**Re: PA22-040 – 87th & 40th PRD – Technical Review 1
4218 / 4112 / 4018 / 3922 / NNA 87th Ave NE
CORE Project No. 21036**

The purpose of this letter is to provide a response to the review comments for PA22-040 – 87th & 40th PRD – Technical Review 1 - 4218 / 4112 / 4018 / 3922 / NNA 87th Ave NE dated October 21, 2022. We have addressed each comment and revised the plan/documentation accordingly. This letter contains the review comments immediately followed by our response to each in bold lettering.

SHEET	OF
C1.03	30
PROJECT NUMBER	
21036

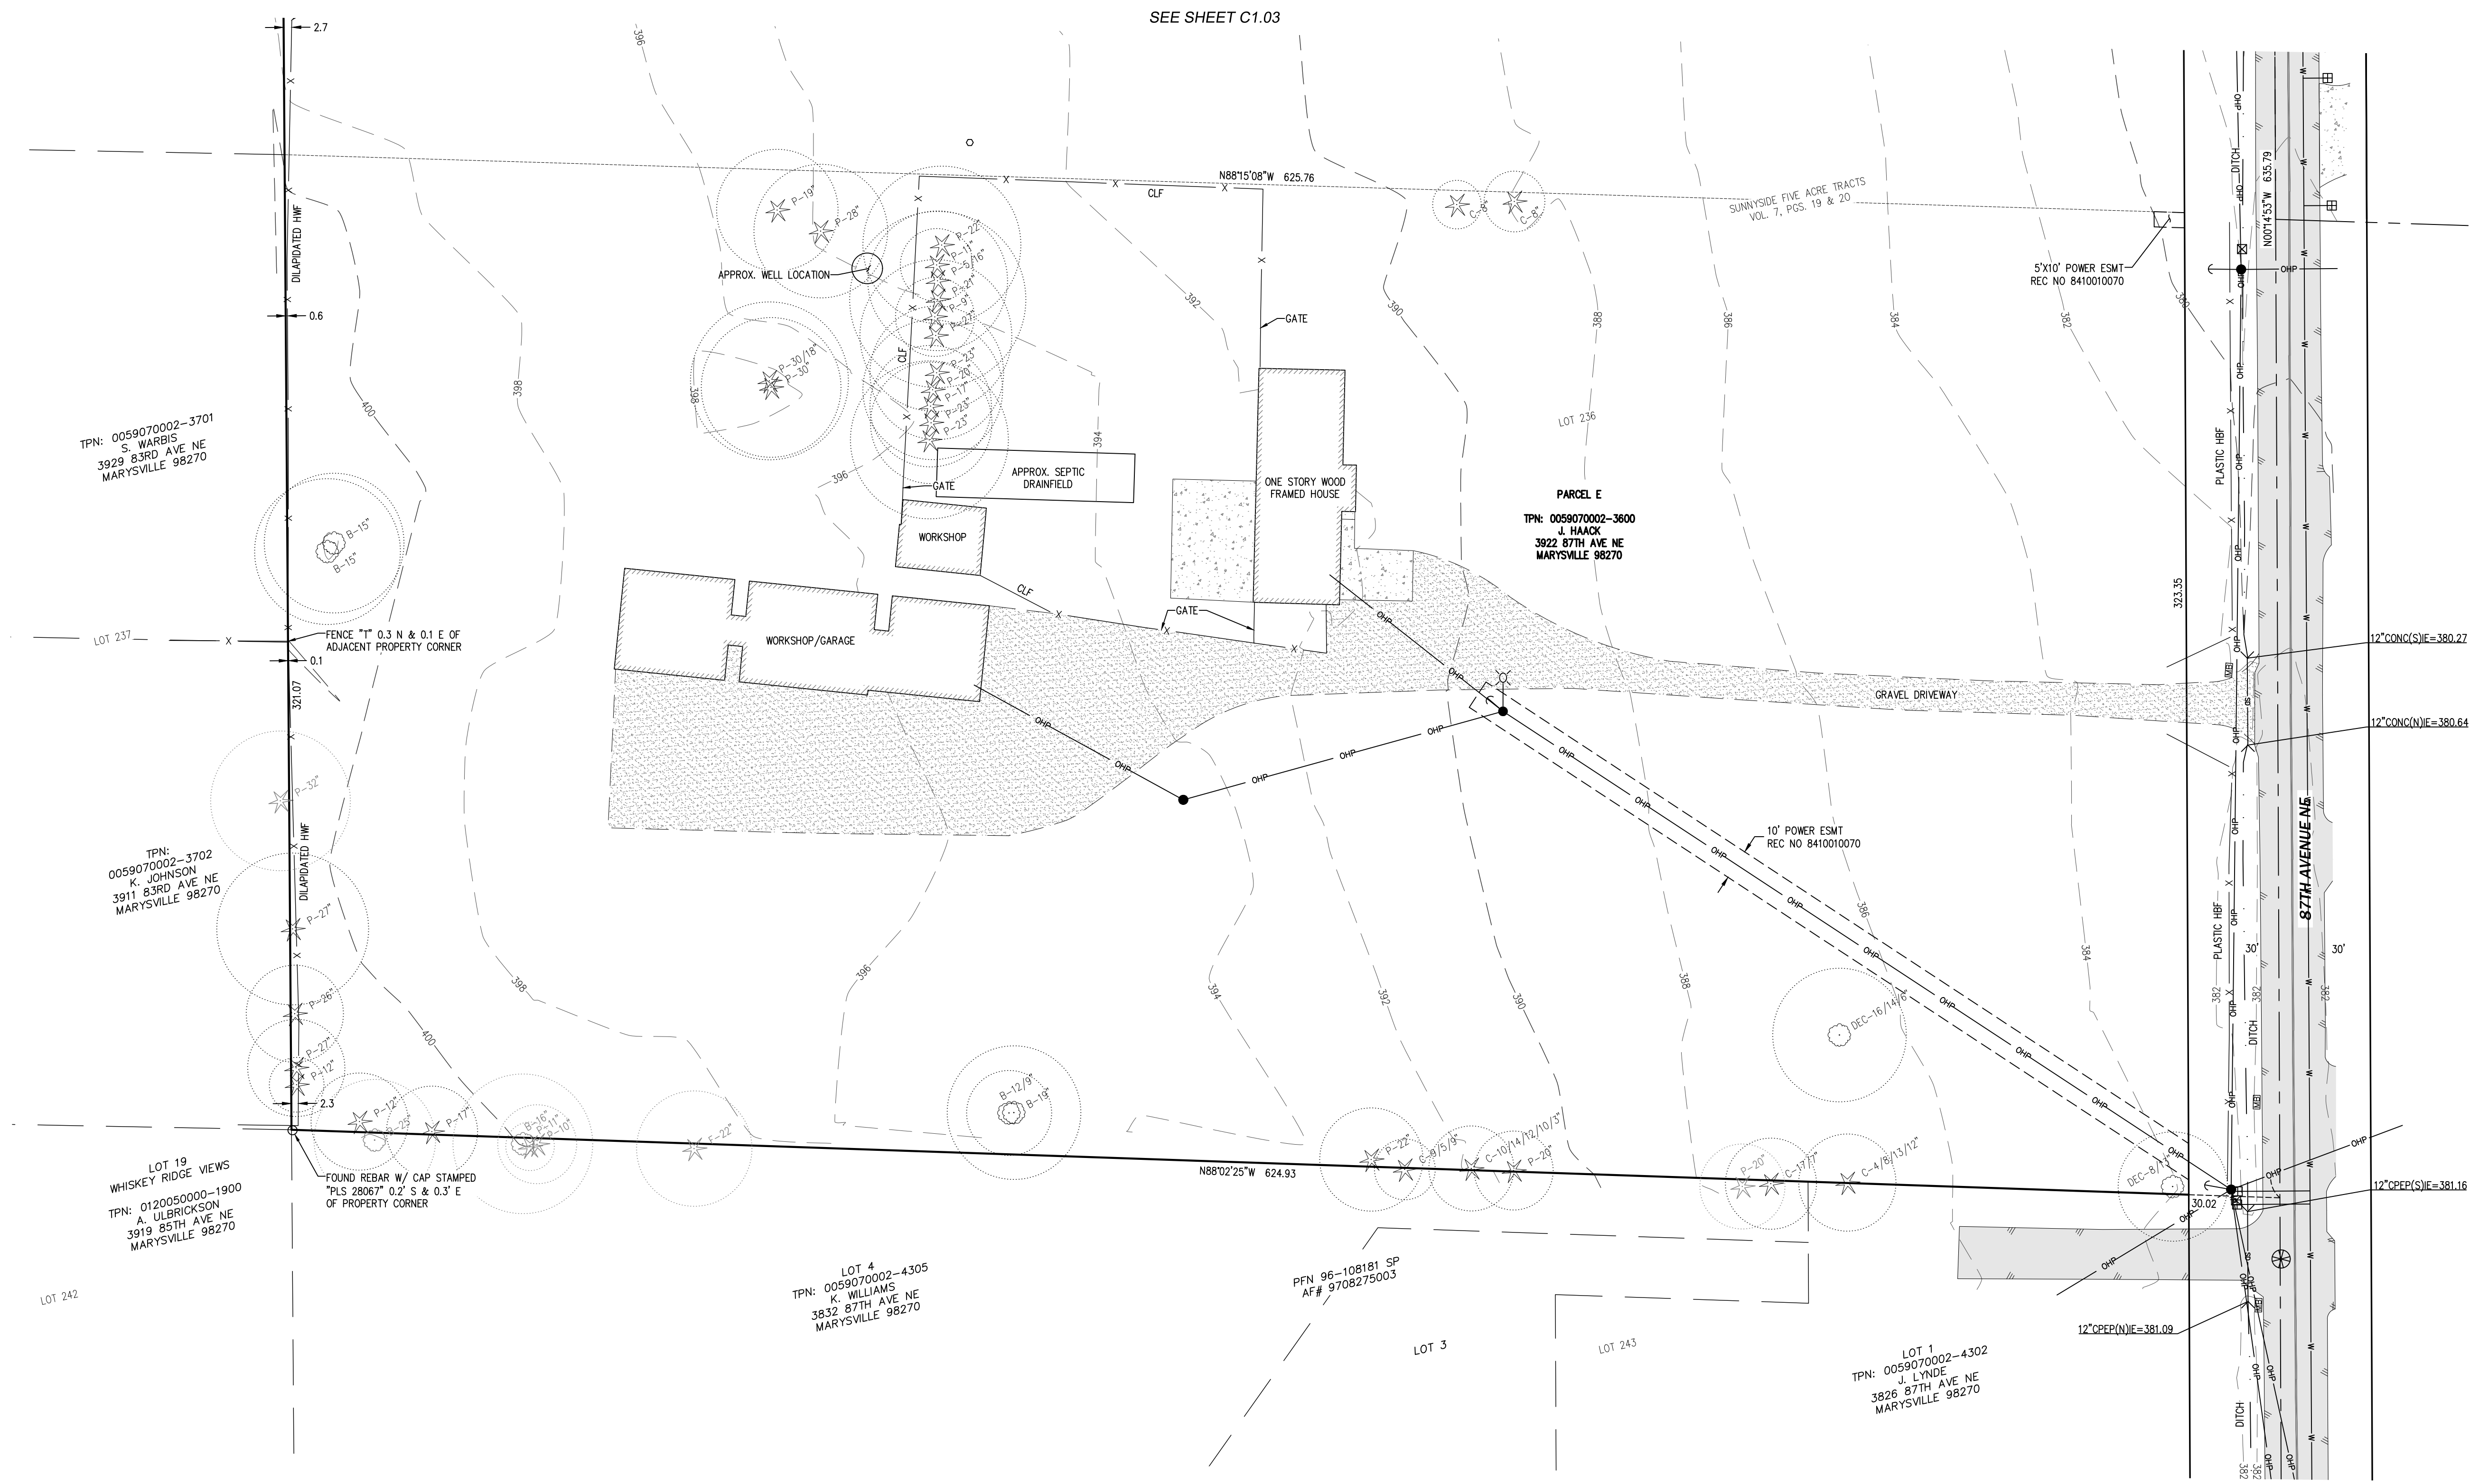
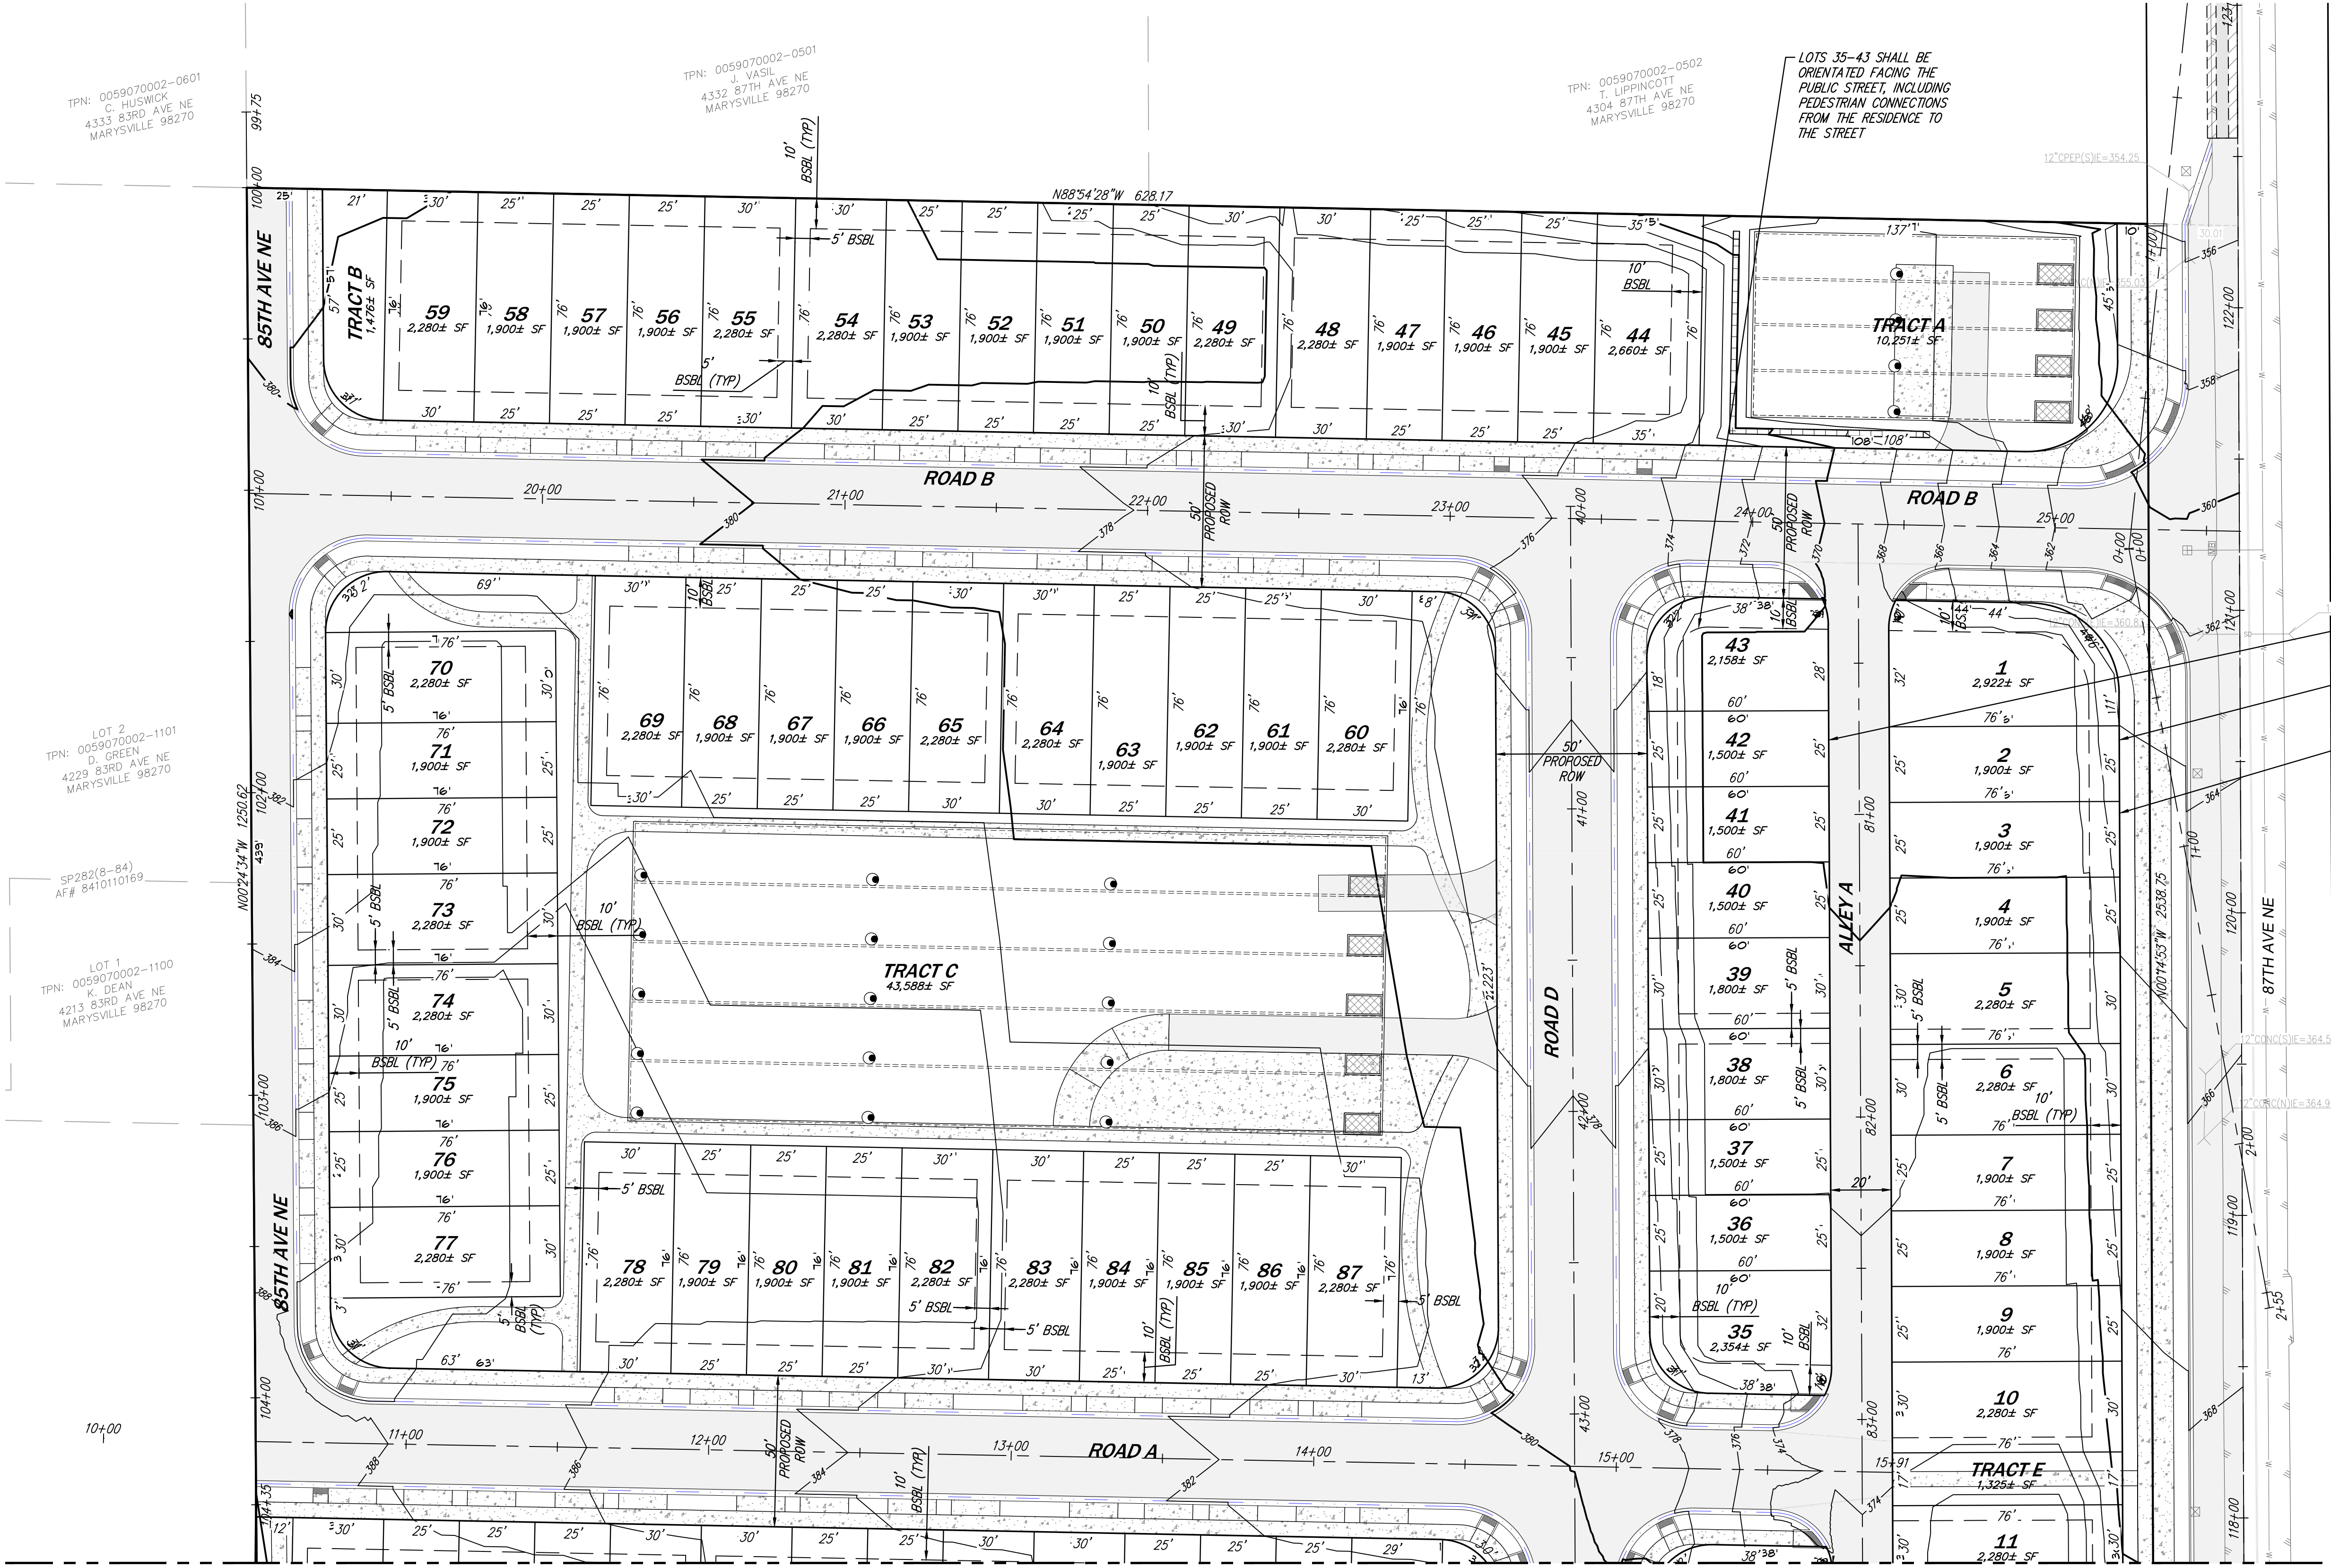
3. Amend Sheets C1.03 & C1.04 to depict all encumbrances outlined in the Title Report, prepared by Chicago Title Insurance Company, dated August 30, 2022. If the encumbrances cannot be depicted they will need to be referenced.

Response: All encumbrances are shown on sheets C1.03 and C1.04

GRIND AND OVERLAY ALONG FULL EXTENTS OF FRONTAGE. HALF STREET FULL DEPTH REPLACEMENT REQUIRED IF EXISTING PAVEMENT DEPTH LESS THAN 3", CONTRACTOR TO VERIFY. SEE SECTION E-E, SHEET 4.31

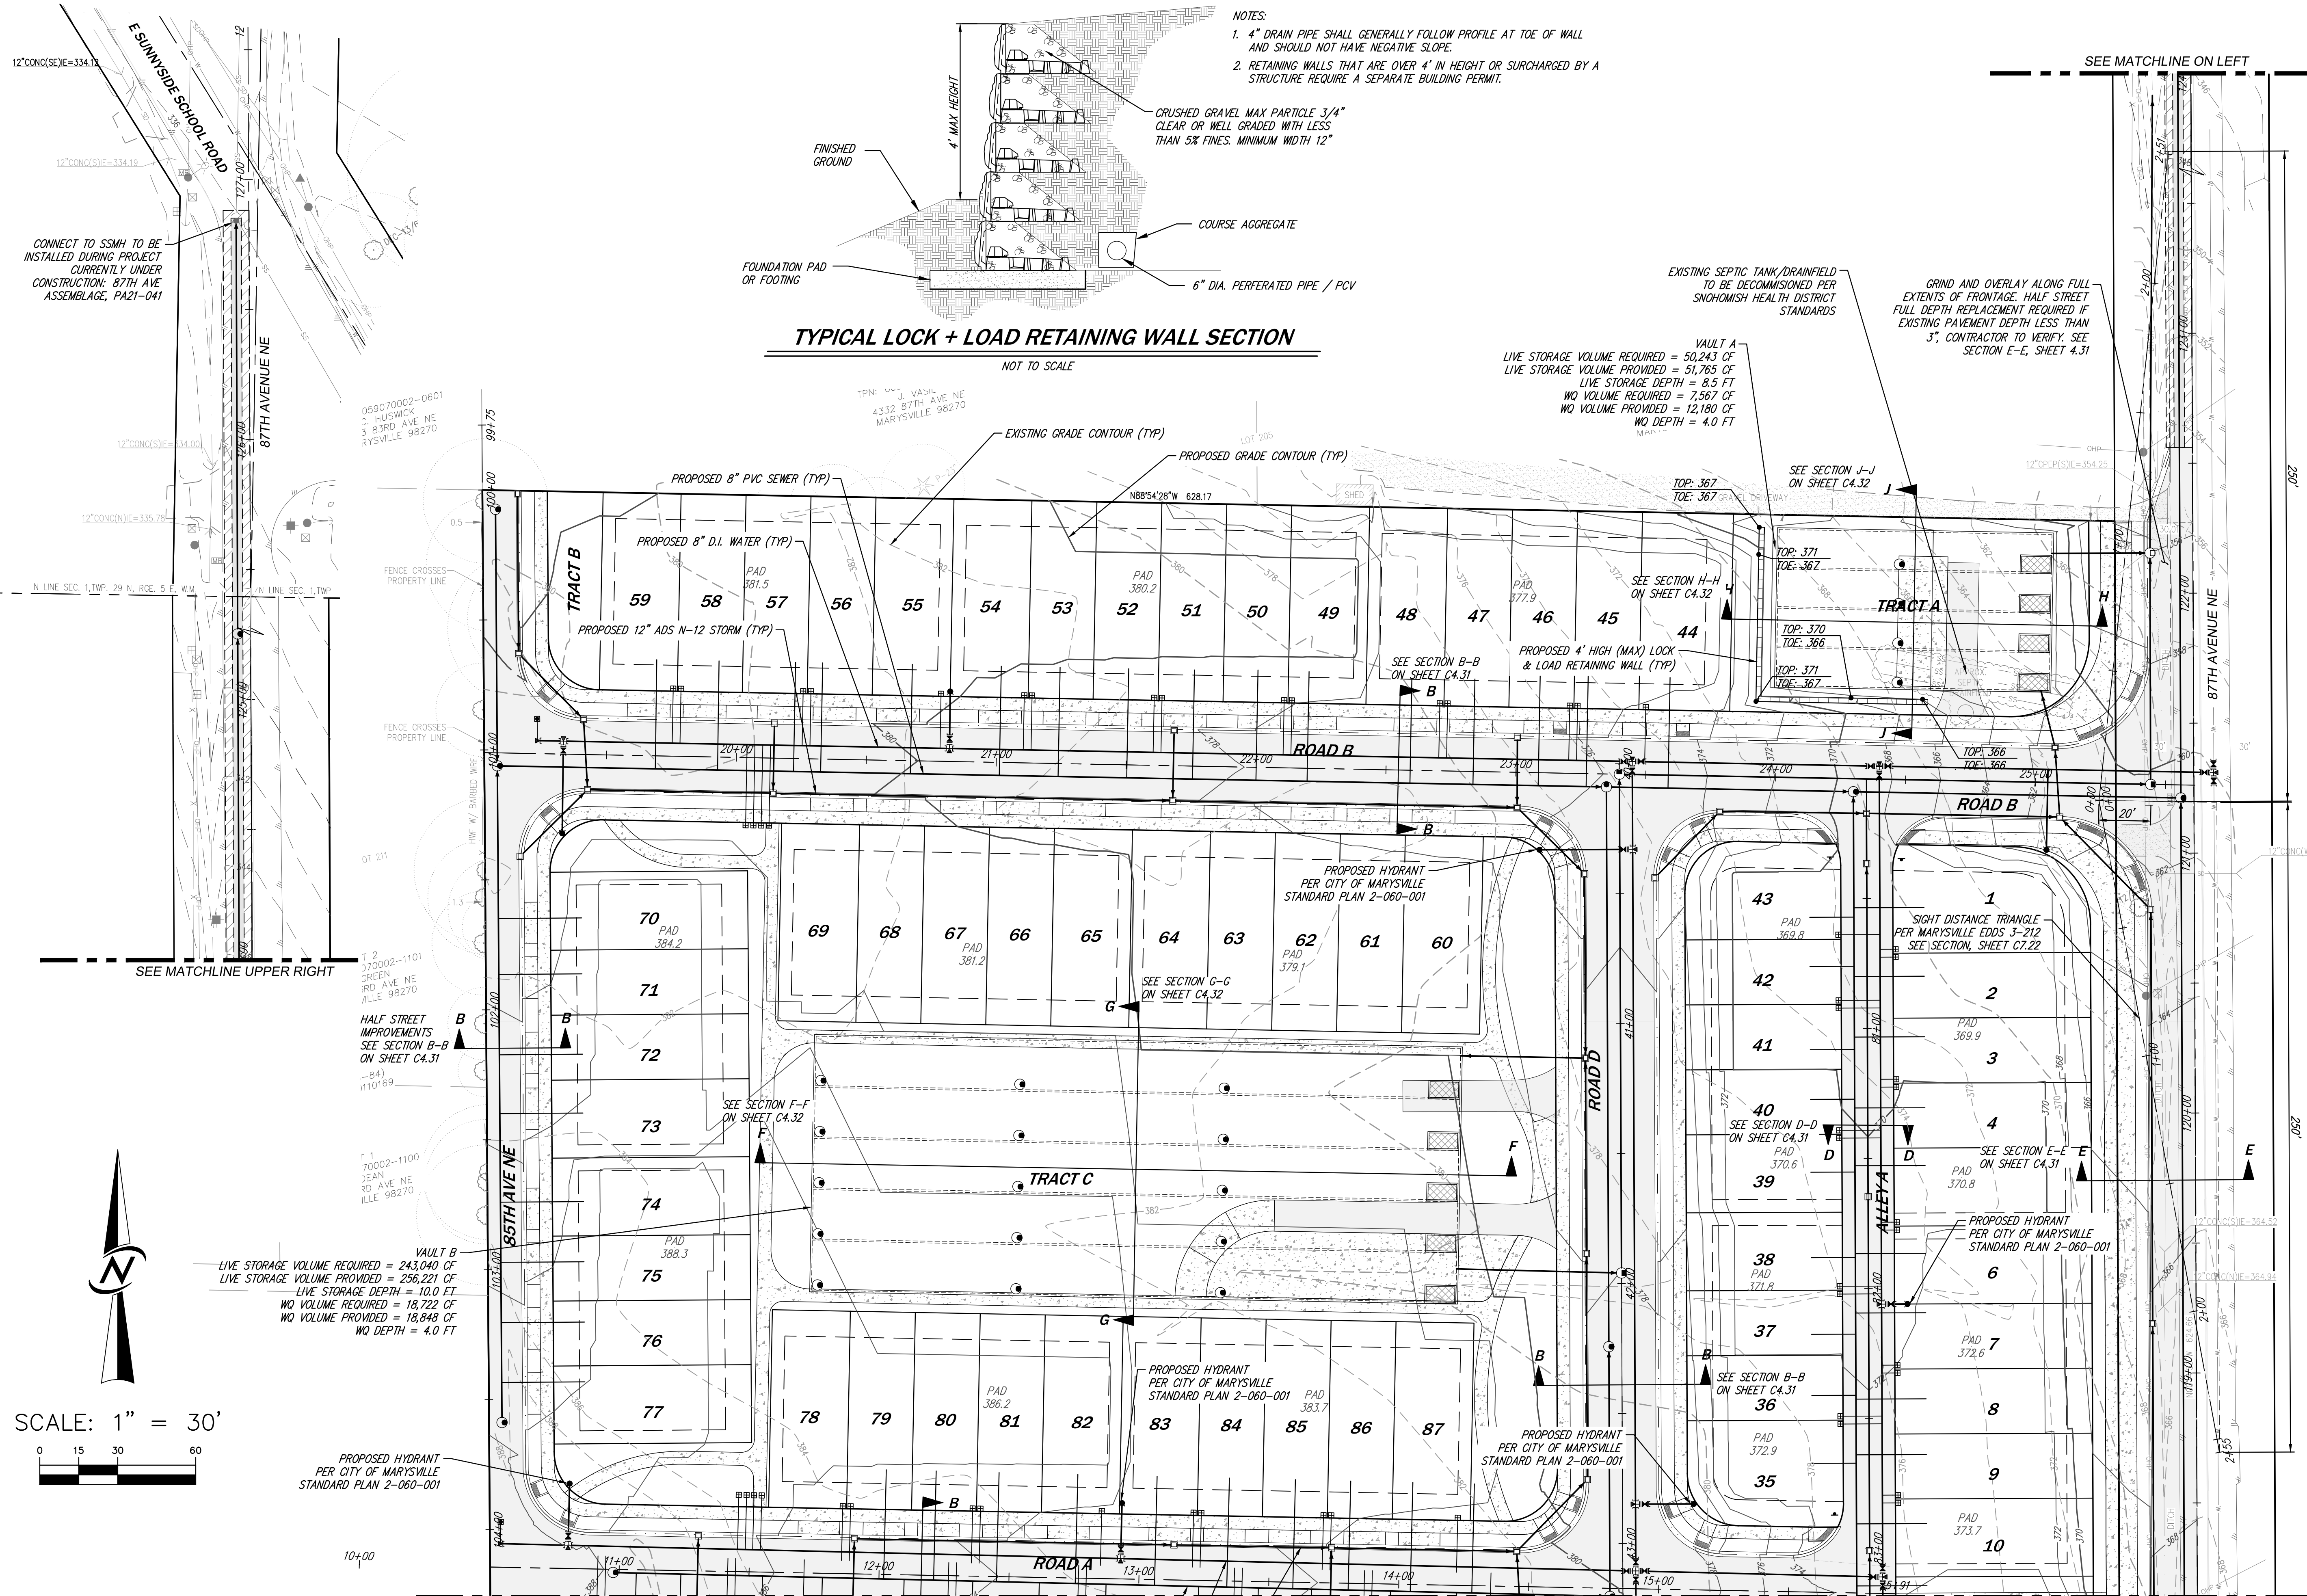
- a. The roadway will require a grind and overlay to the center of the right-of way. Many sections of 87th Ave NE do not have more than 3” of asphalt in total. Should this be the case along the projects frontage when constructing the frontage improvements, a full depth replacement will be required up to the centerline along the projects frontage.

Response: Acknowledged. During civil construction it shall be contractors responsibility to verify thickness of asphalt and a full depth replacement will be provided at that time if required. A note has been added to the plans stating this.
